Application No: EP/67/20/PL
Site Address: Land adjacent to 45 The Ridings East Preston BN16 2TW
Description of works: 1 No. detached house & formation of associated new access.

Thank you for your internet representation made on 18th June 2020 which has been recorded as an objection with the comments as follows:

DRAWING TITLE
PROPOSED SITE LAYOUT

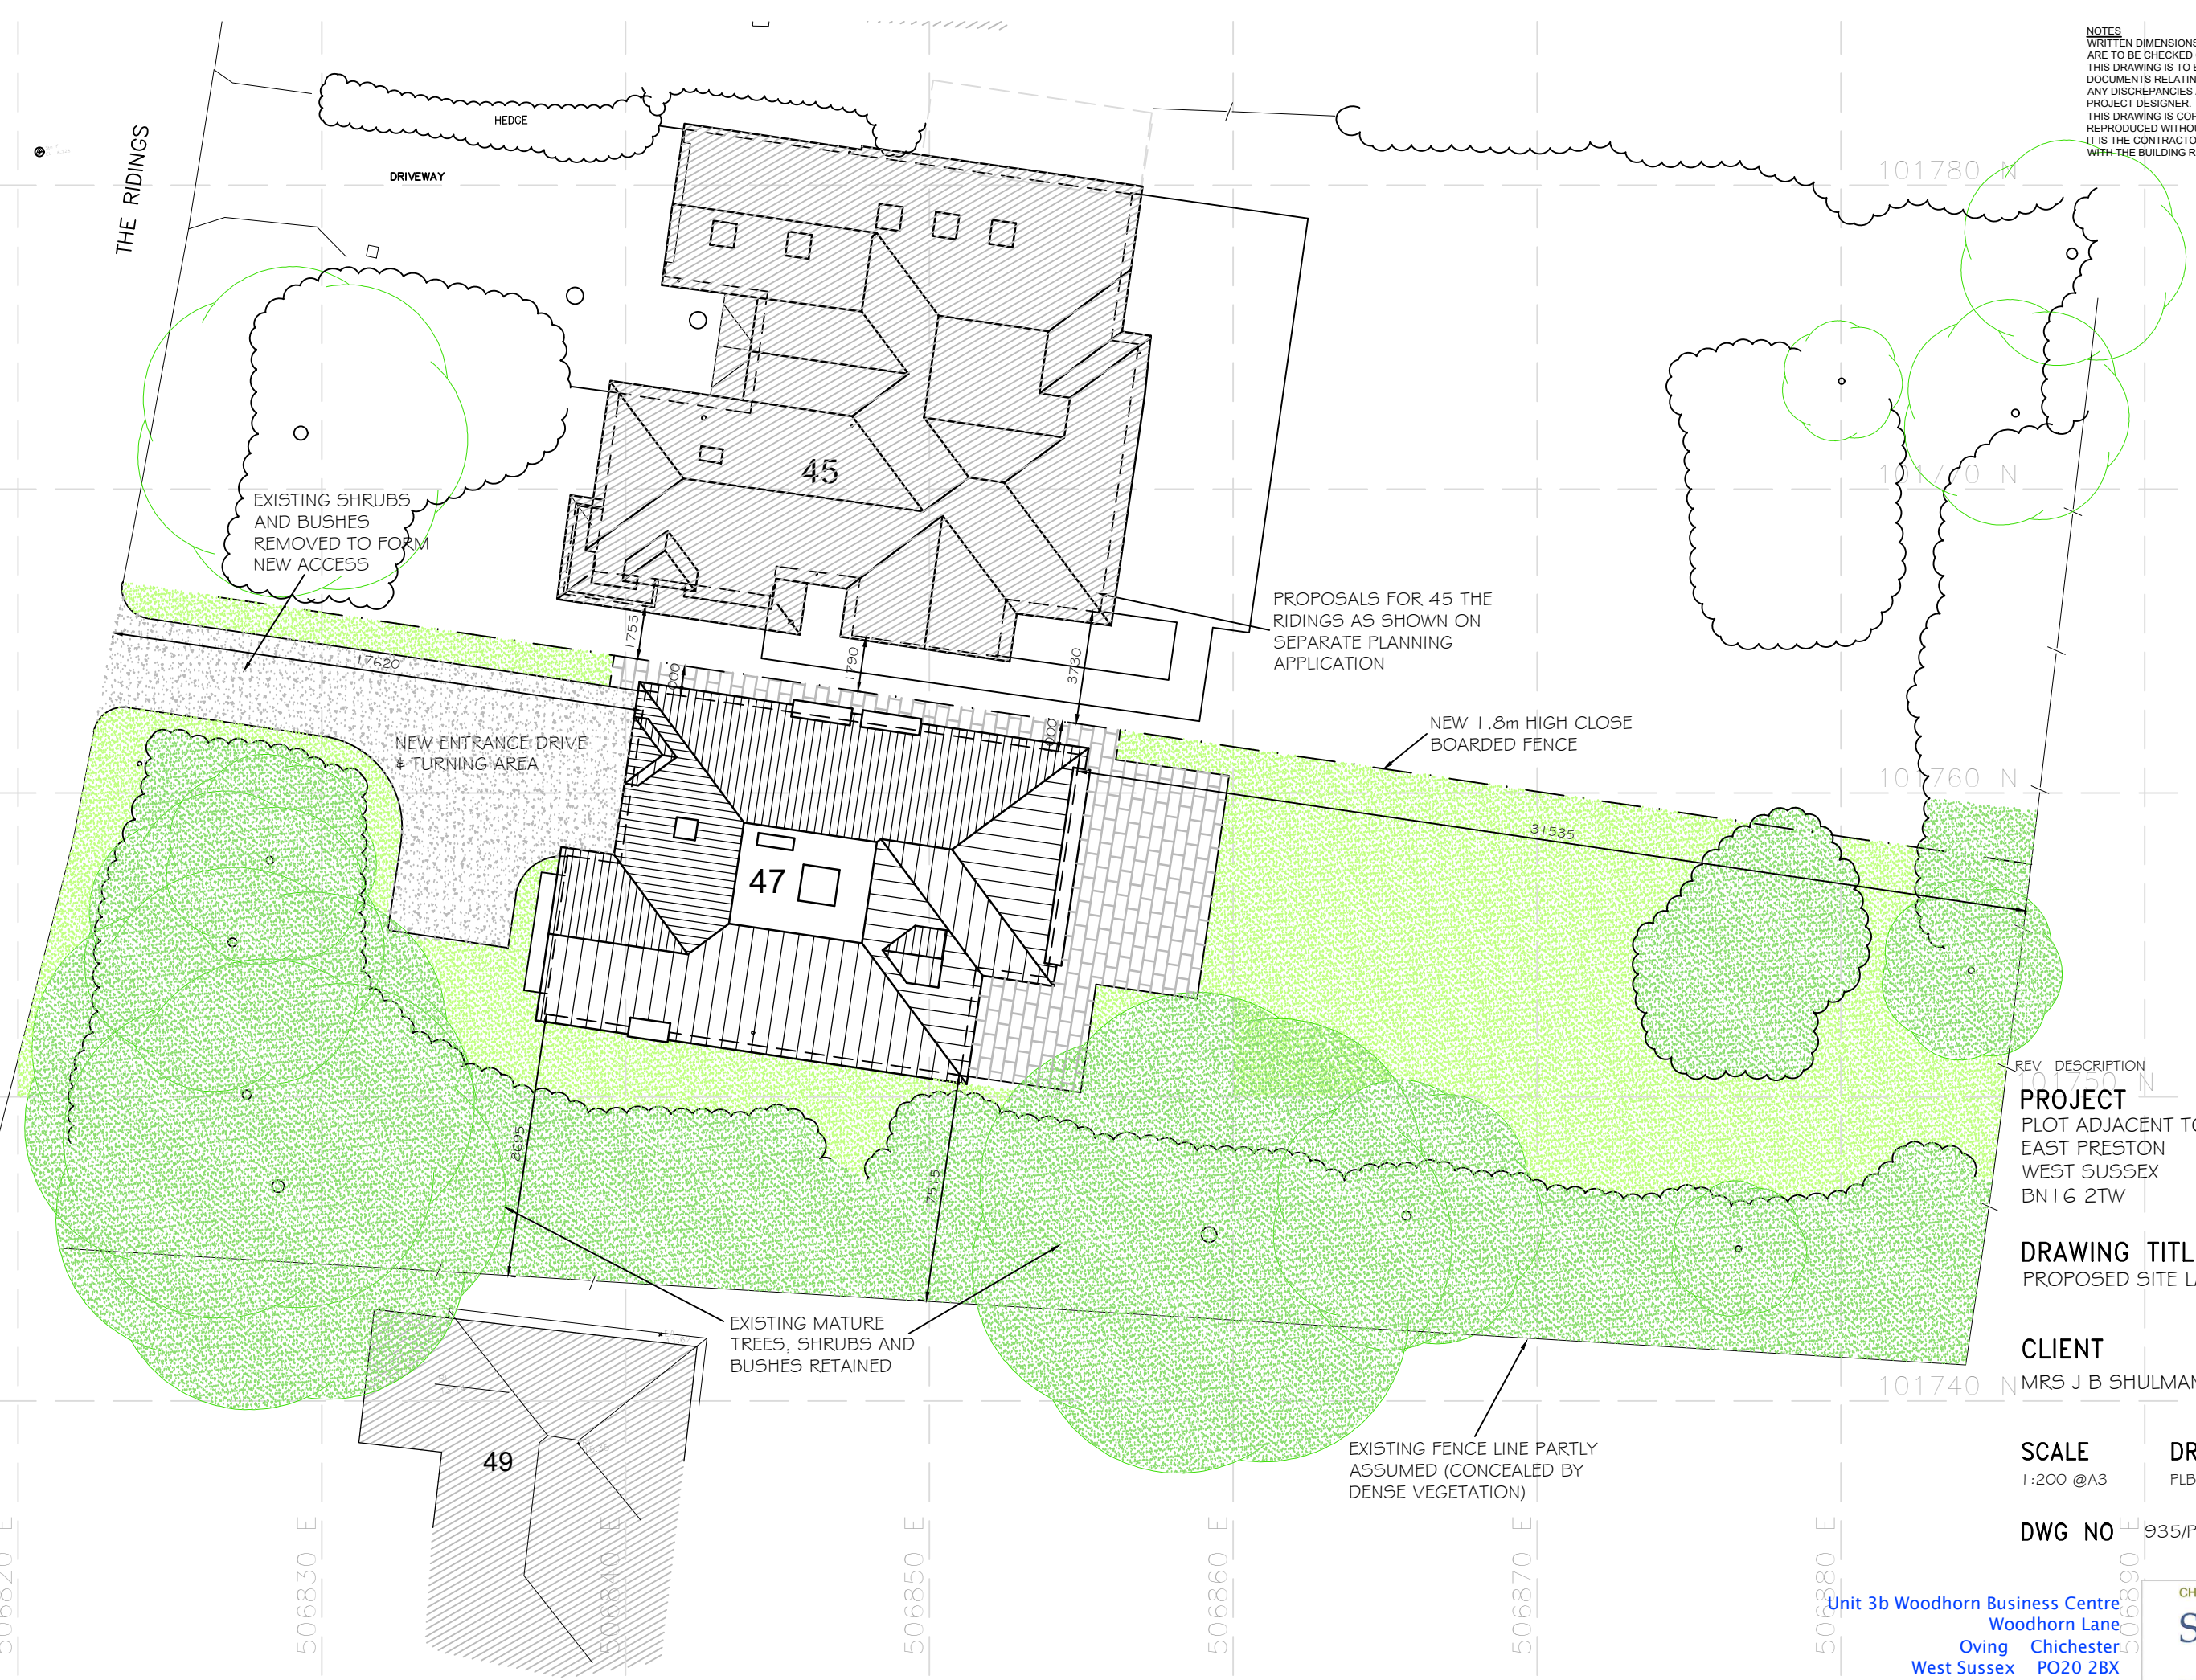
The proposed house is vastly oversized, I see a very small garage with limited drive space so I assume as parking on the road is not permitted, it would be owner occupied by a couple with one car and a bicycle each.

With the potential of such a large development we would also ask that a strict traffic management plan be developed as part of the planning application, which considers none parking on the road, access and egress from the development for all vehicles, working hours, noise reduction measures, material storage, and dust control. This is to minimise the disruption and damage to The Ridings and the occupants. Presumably as part of the planning application process a full dilapidations survey will be carried out prior to any works to the development and surrounding adjacent vehicle routes.
